Please ask for: Ms Iqraa Malik  
Email: [iqraa.malik@terraquest.co.uk](mailto:iqraa.malik@terraquest.co.uk)  
Telephone: 0121 234 1390  
Our Ref: FP/251/21/PL  
Your Ref:  
Date: 4th January 2022

Application for Planning Permission

Development: Erection of single storey rear extension following the demolition of existing lean to.  
Location: 5 Davenport Road Felpham PO22 7JP

DATE	REVISION	BY
5 Davenport Road Felpham Bognor Regis West Sussex PO22 7JP		
DRAWN RD	CHECKED	
SCALE 1:50	DATE 01.01.22	
PROJECT TITLE Proposed Extension to 5 Davenport Road		
DRAWING TITLE Existing Ground Floor Plan		
DWG NUMBER 001		REV
NEG NUMBER

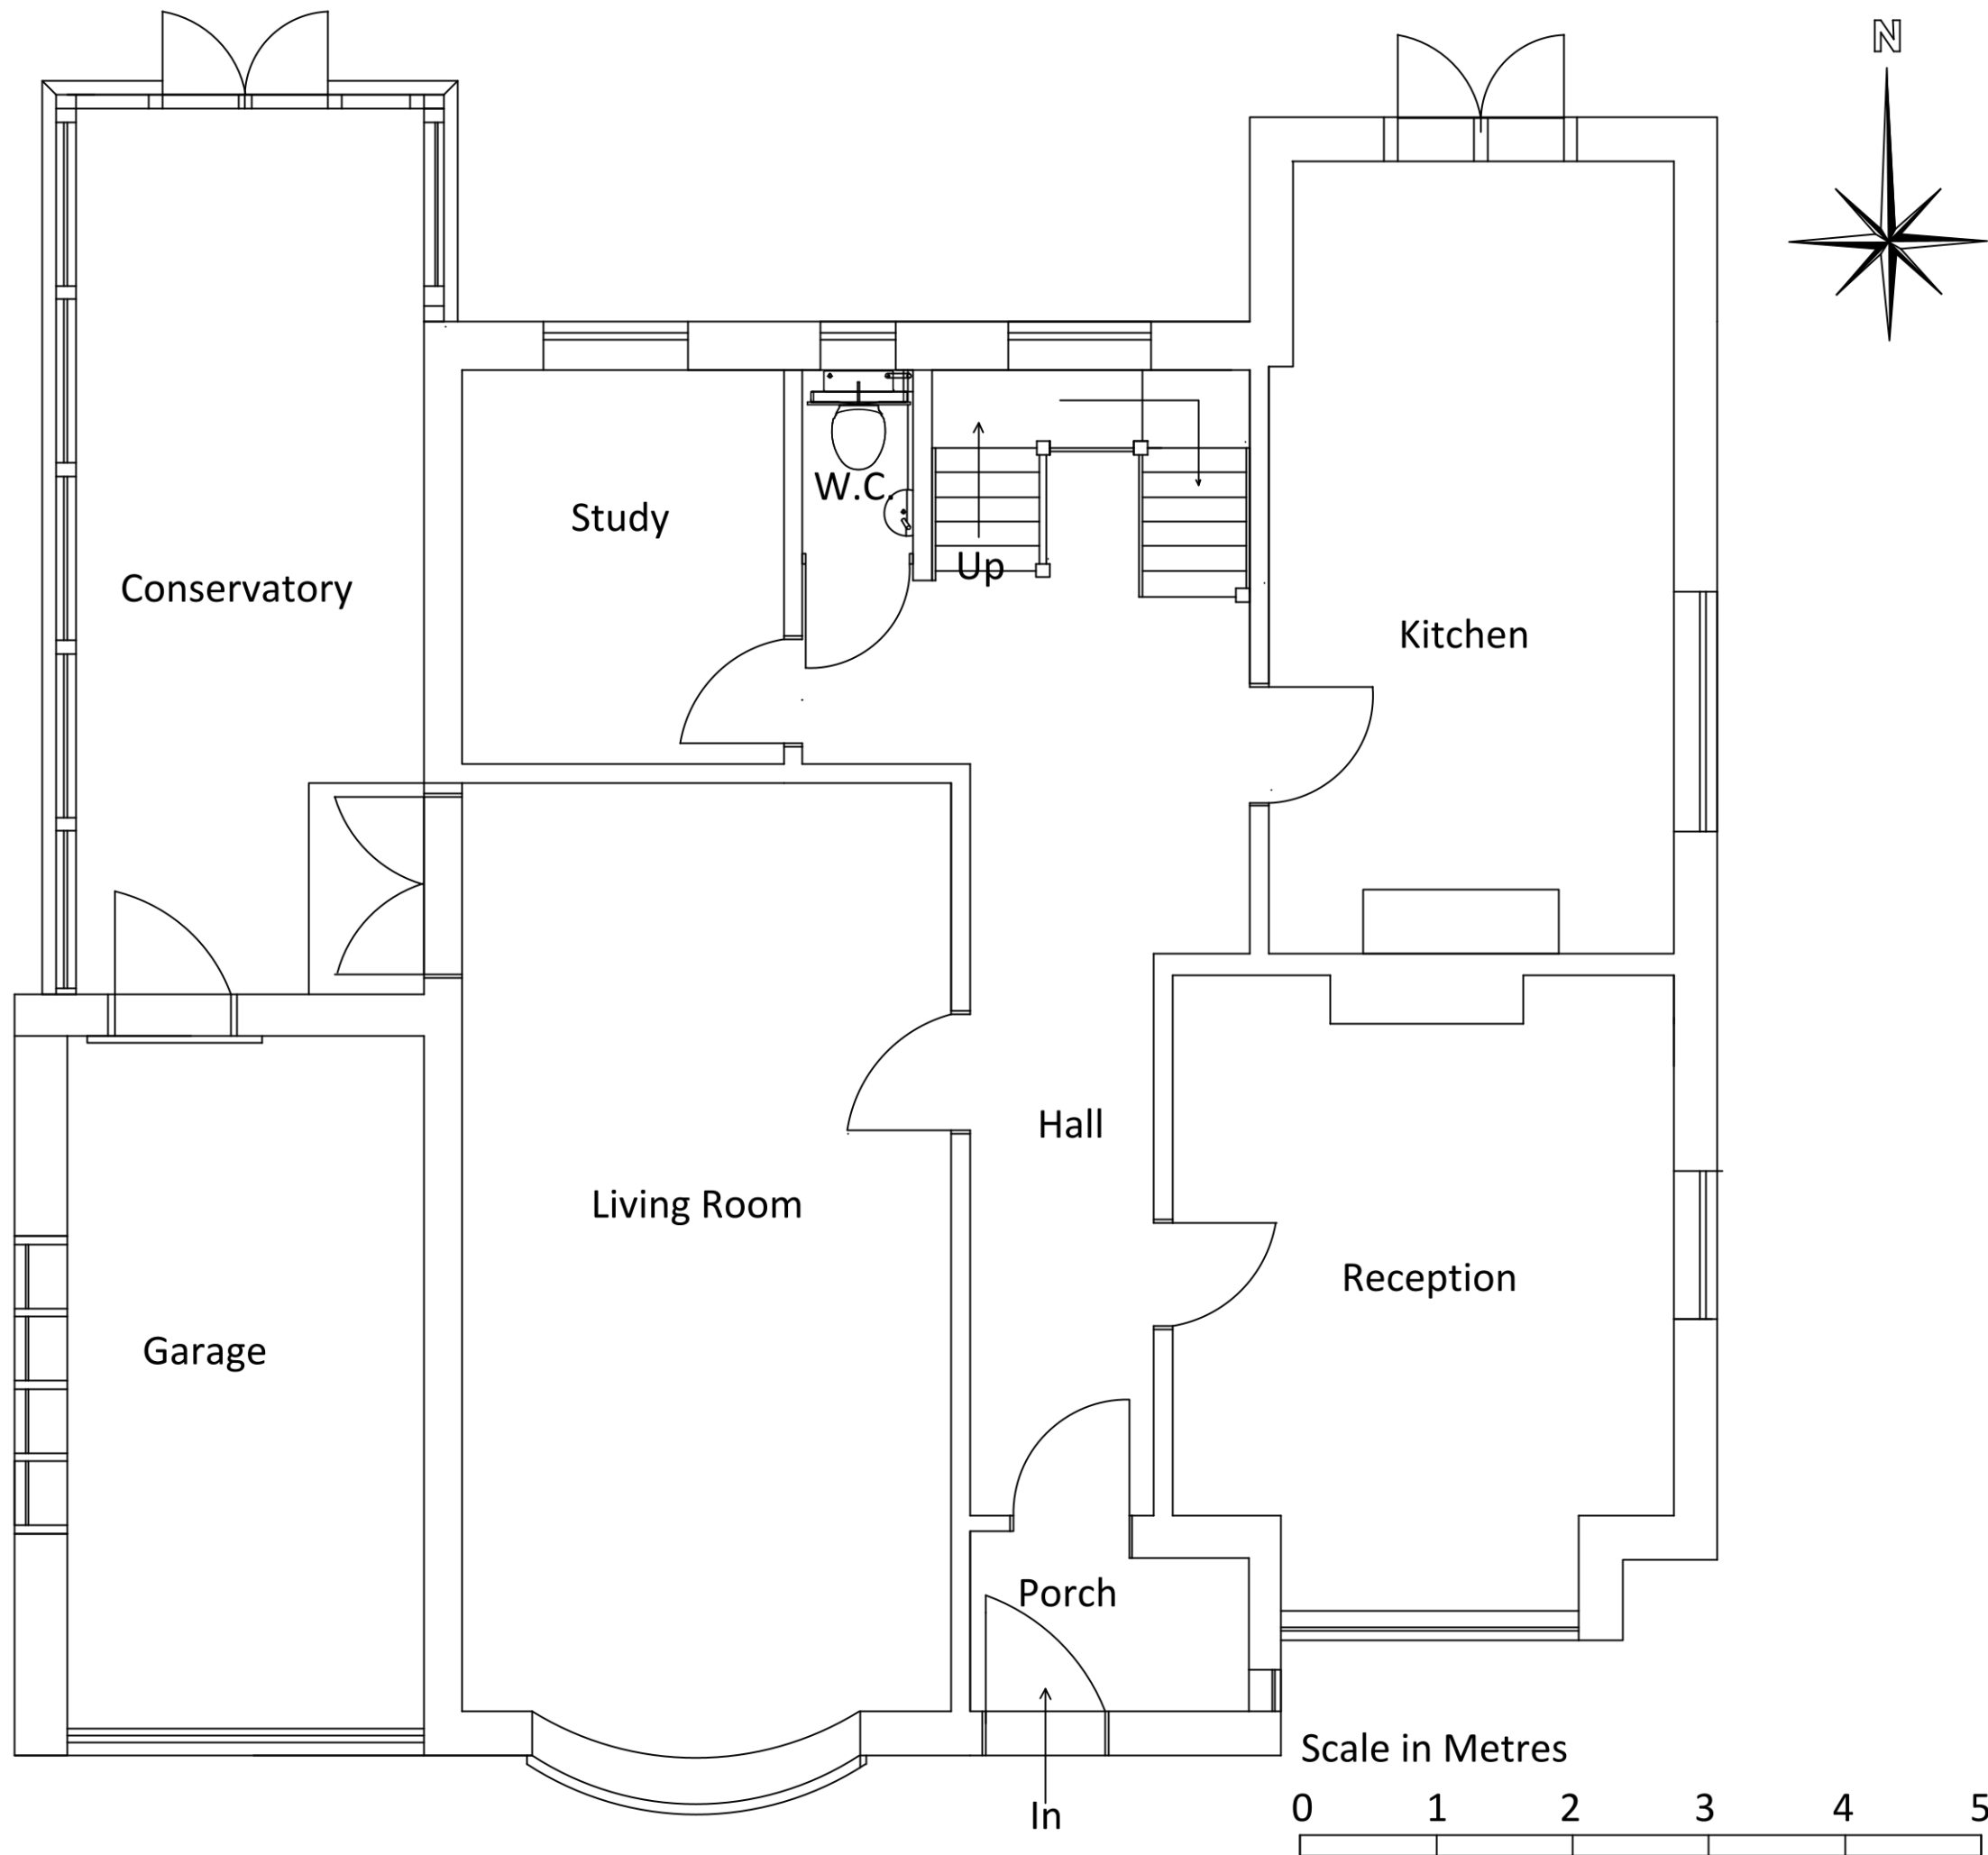
Please submit clearly labelled existing floor plans and elevations at a scale of 1:50 or 1:100. Further details can be found in the Validation Requirements List.

LOCATION PLAN

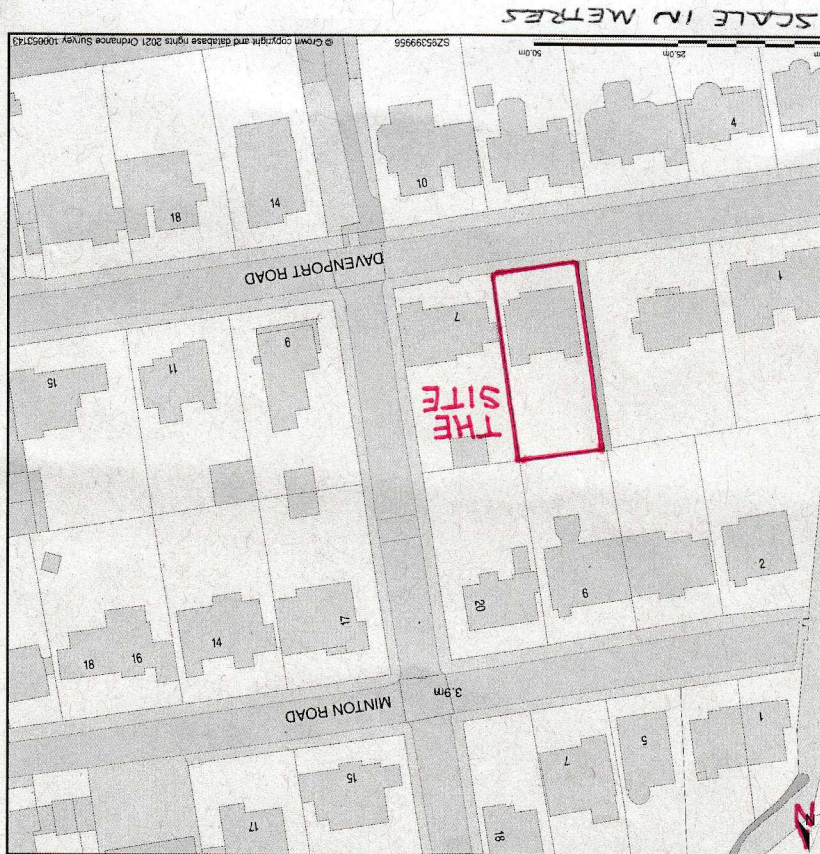
The location plan requires a solid red outline around the site boundary. Further details of what must be included on the plan can be found in the Validation Requirements List.

DATE	REVISION	BY
5 Davenport Road Felpham Bognor Regis West Sussex PO22 7JP.		
DRAWN RD	CHECKED	
SCALE 1:50	DATE 06.01.22	
PROJECT TITLE Proposed Extension to 5 Davenport Road		
DRAWING TITLE Proposed East Elevation		
DWG NUMBER 007	REV	
NEG NUMBER

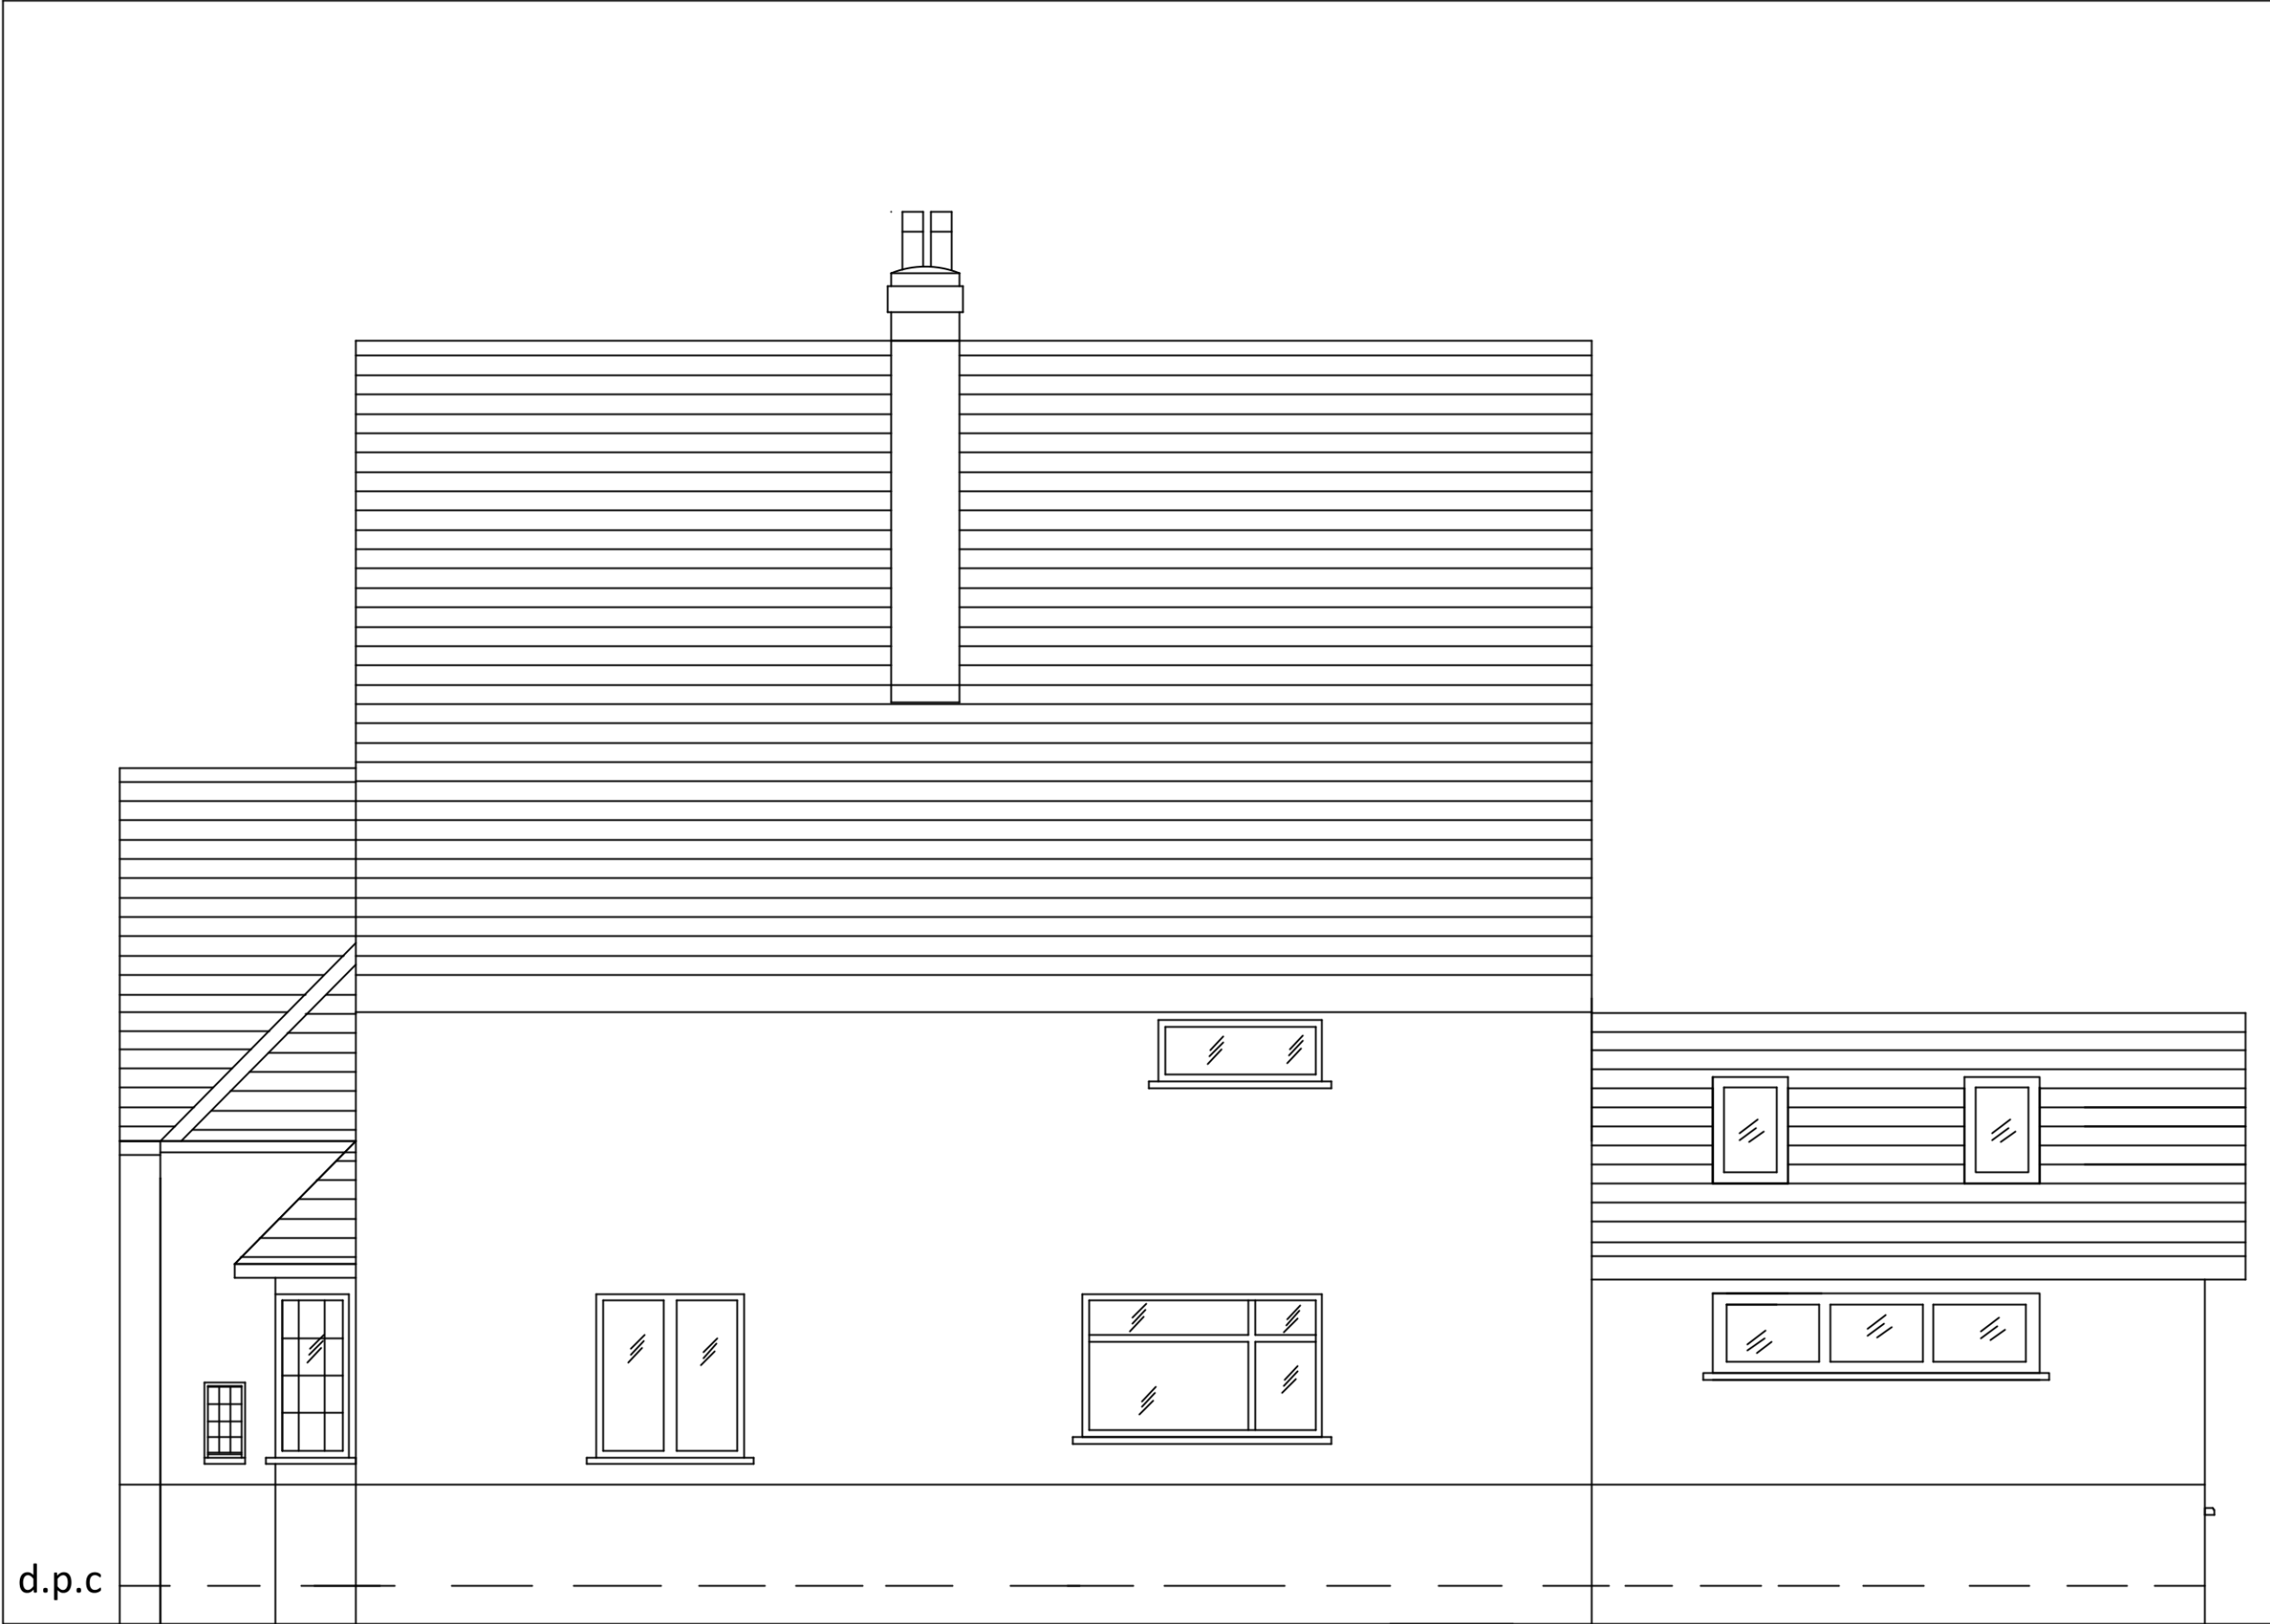
Please submit proposed elevations at a scale of 1:50 or 1:100. Along with this, the proposed floor plans require a stated scale. Further details can be found in the Validation Requirements List.
